OFFICIAL NOTICE OF DECISION

CITY OF ALBUQUERQUE
PLANNING DEPARTMENT
DEVELOPMENT REVIEW BOARD

1. Project # 1002663

GREATER ALBUQUERQUE HOUSING PARTNERSHIP request(s) the above action(s) for all or a portion of Tract(s) E, NEW MEXICO CREDIT CORPORATION, (to be known as **EL PORVENIR SUBDIVISION**) zoned SU-2 special neighborhood zone, C-3, located on ARNO ST NE, between LOMAS BLVD NE and MARBLE AVE NE containing approximately 2 acre(s). [REF:03DRB-00804 (SK)] (J-14)

**PLAT OF
LOTS 1 thru 13
EL PORVENIR SUBDIVISION
SITUATE WITHIN SECTION 17,
T. 10 N., R. 3 E., N.M.P.M.
CITY OF ALBUQUERQUE
BERNALILLO COUNTY, NEW MEXICO
OCTOBER 2003
SHEET 2 OF 2**

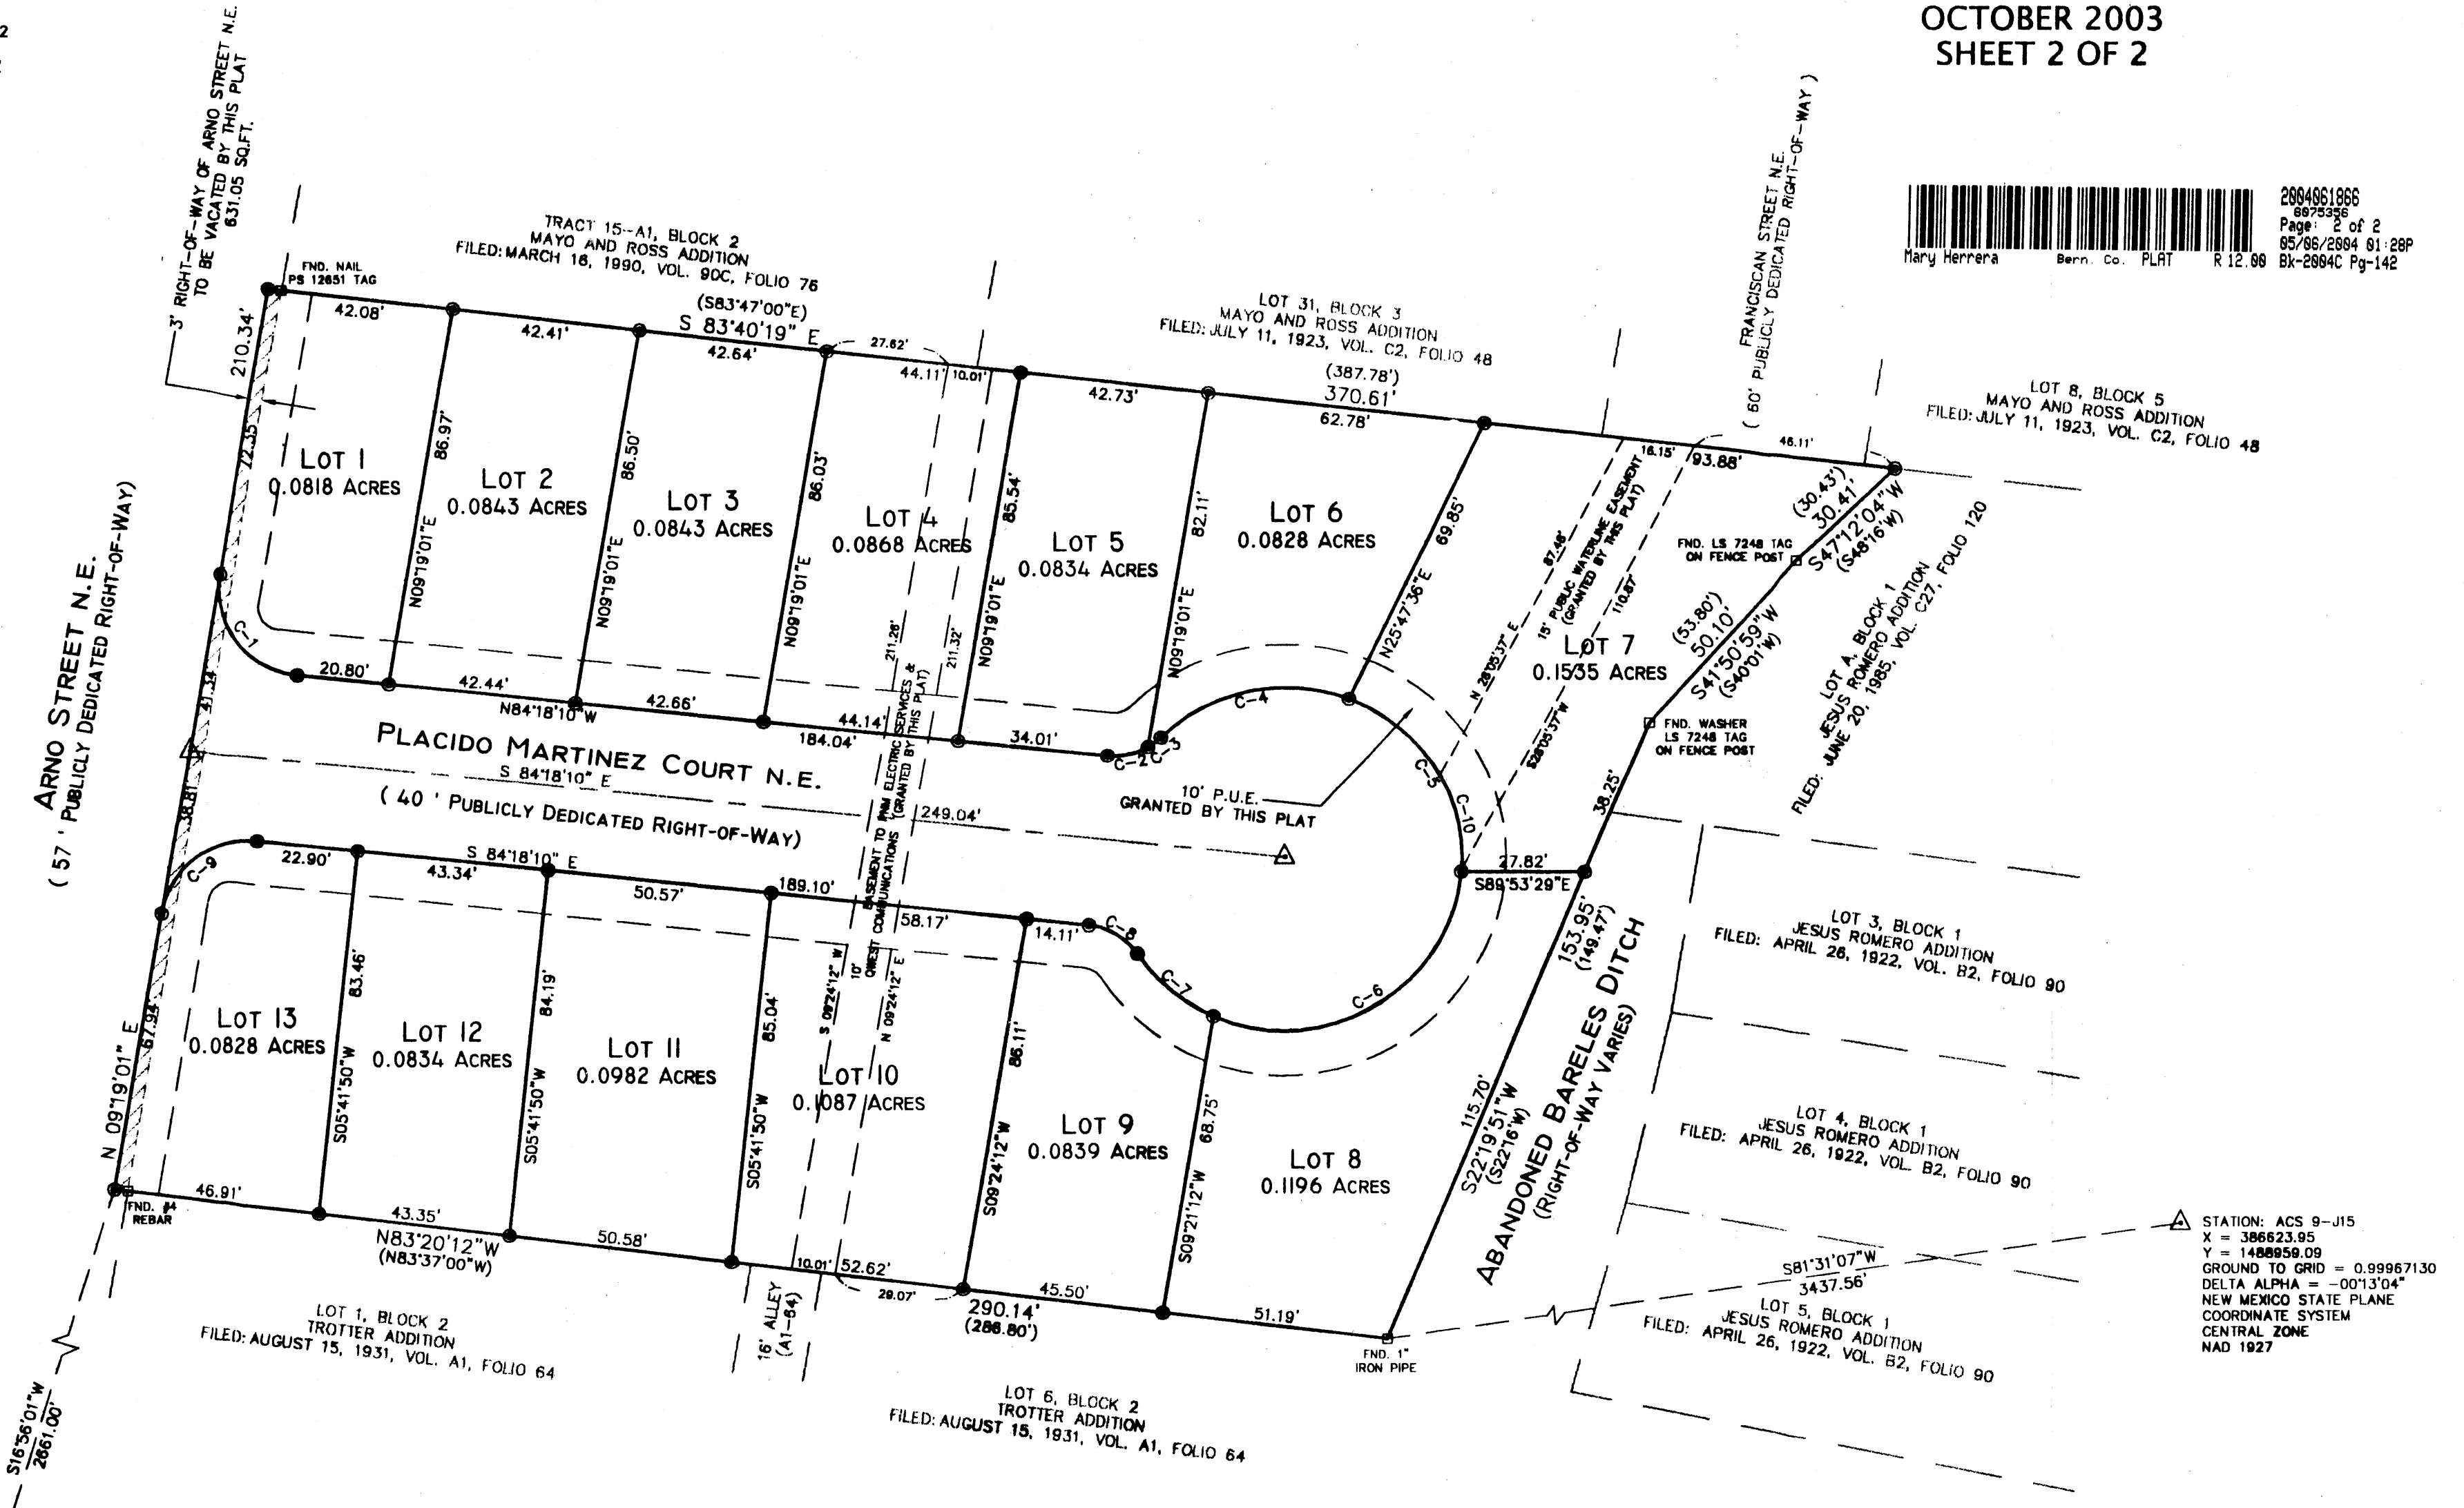
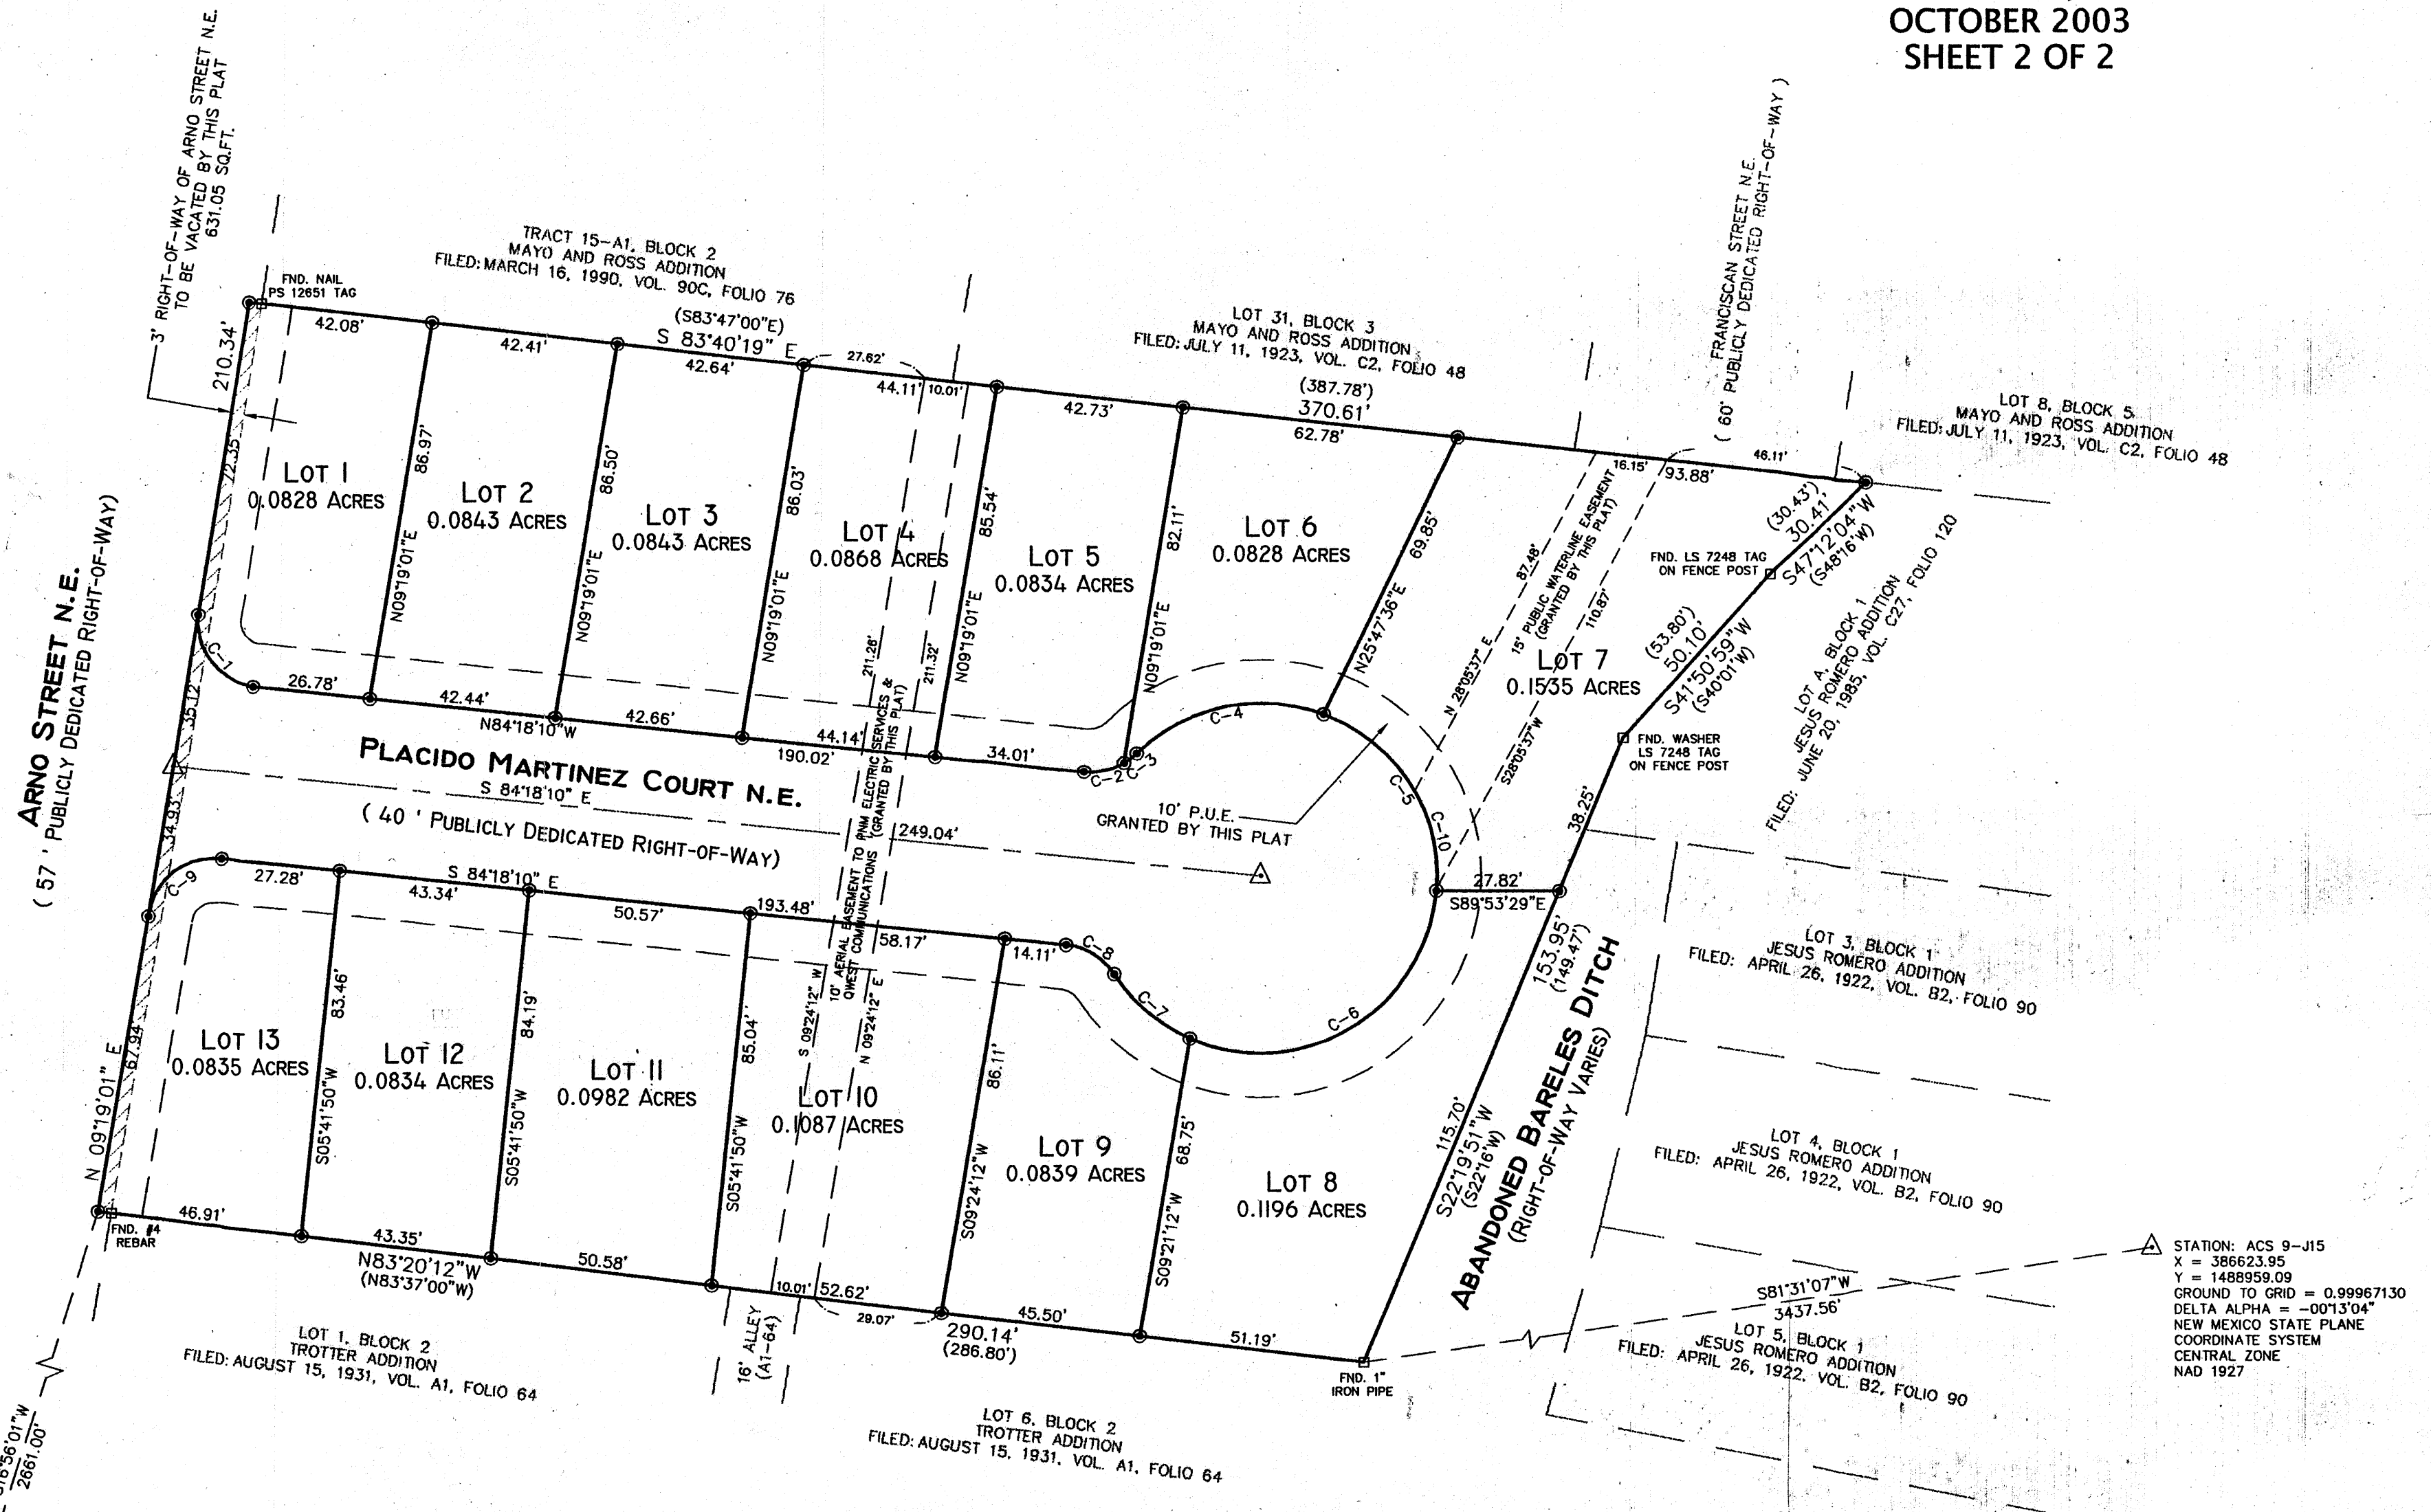
- 1) Reflect the radius as 20-feet instead of 15-feet.
